From: Karl Okorn <karl.okorn@auburn.nsw.gov.au>
Sent: Friday, 6 March 2015 2:09 PM
To: Andrew Hartcher
Subject: RE: FW: S96(2) submission - 4 Murray Rose Avenue, Sydney Olympic Park (SSD 6076 MOD 1)

Council comments as follows:

Project Title
4MR
4 Murray Rose Avenue SOP NSW 2127 AU
Drawing Title
PLANS
Basement 03

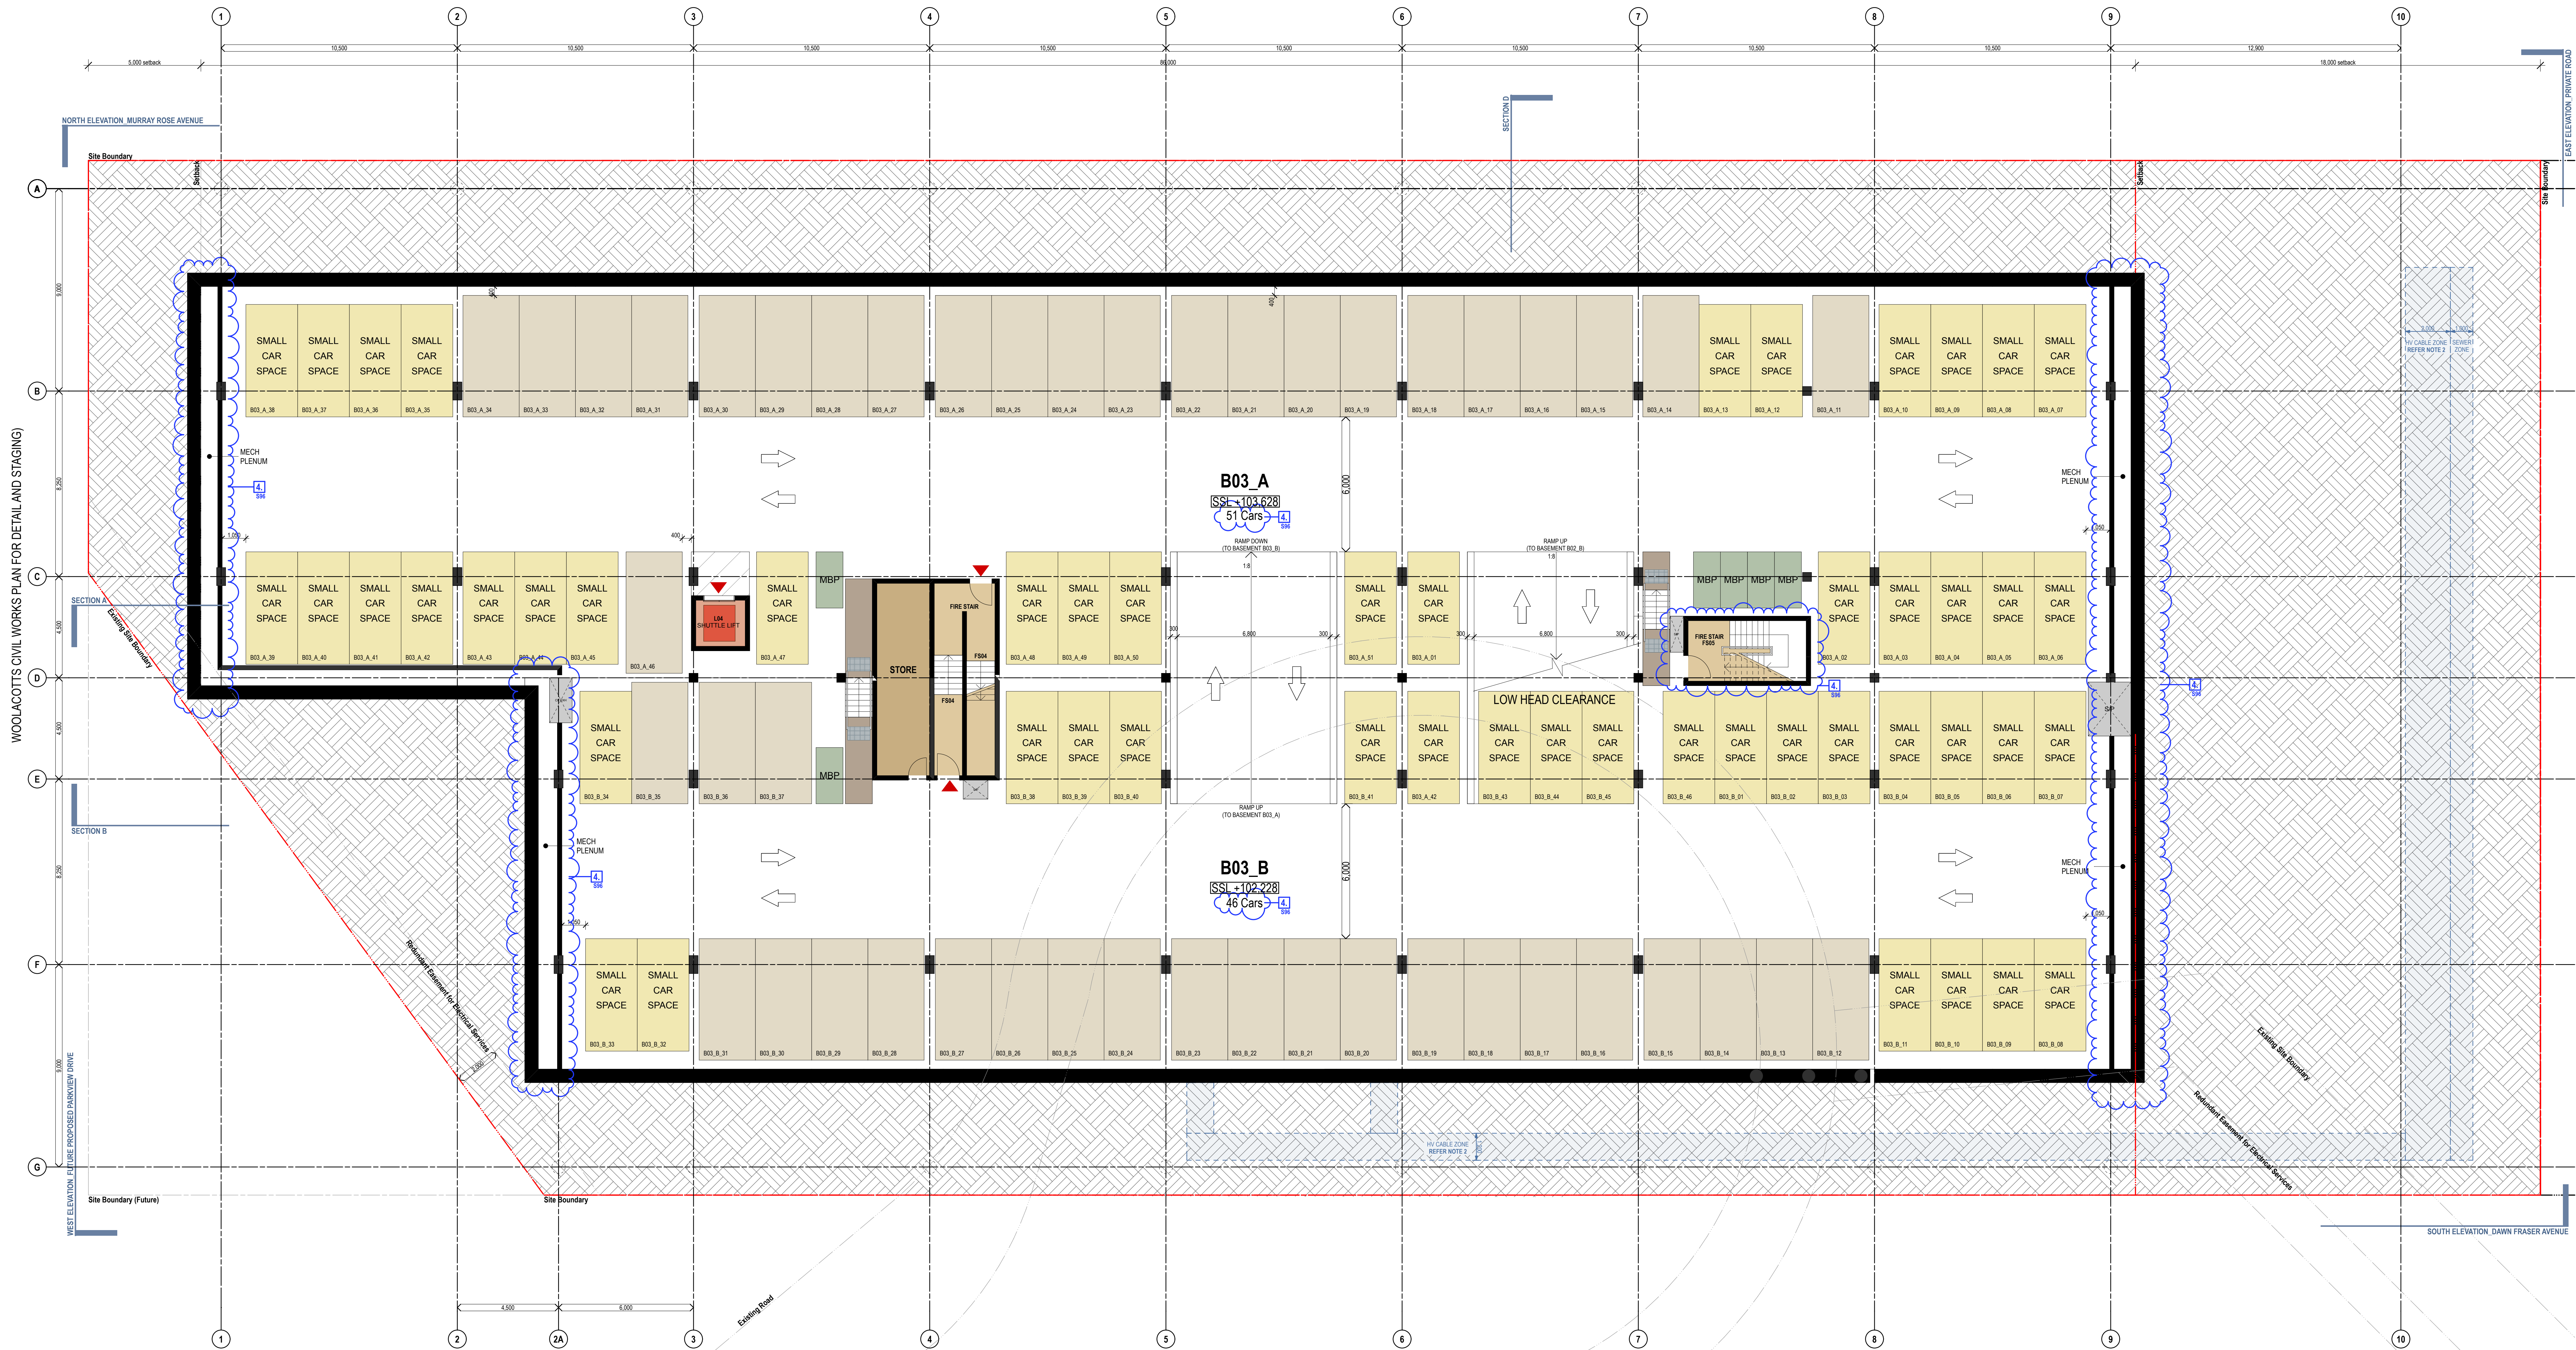
- Car parking design should comply with Australian Standard AS2890.
- Service vehicle access and loading deliveries should occur within the site. Where basement level loading/service delivery is being proposed, minimum headroom clearance of 4.5m is required to allow access for a medium rigid truck (8.8m). Further, where such access to a basement is proposed for service vehicles, adequate manoeuvring space is to be provided within the basement to allow these vehicle to enter and leave the site in forwards direction.
- As a minimum, parking provision should be in accordance with the *RMS Guide for traffic generating development*. It is noted that additional commercial floor area is being proposed in this instance, however a reduction in parking is also intended for the development.
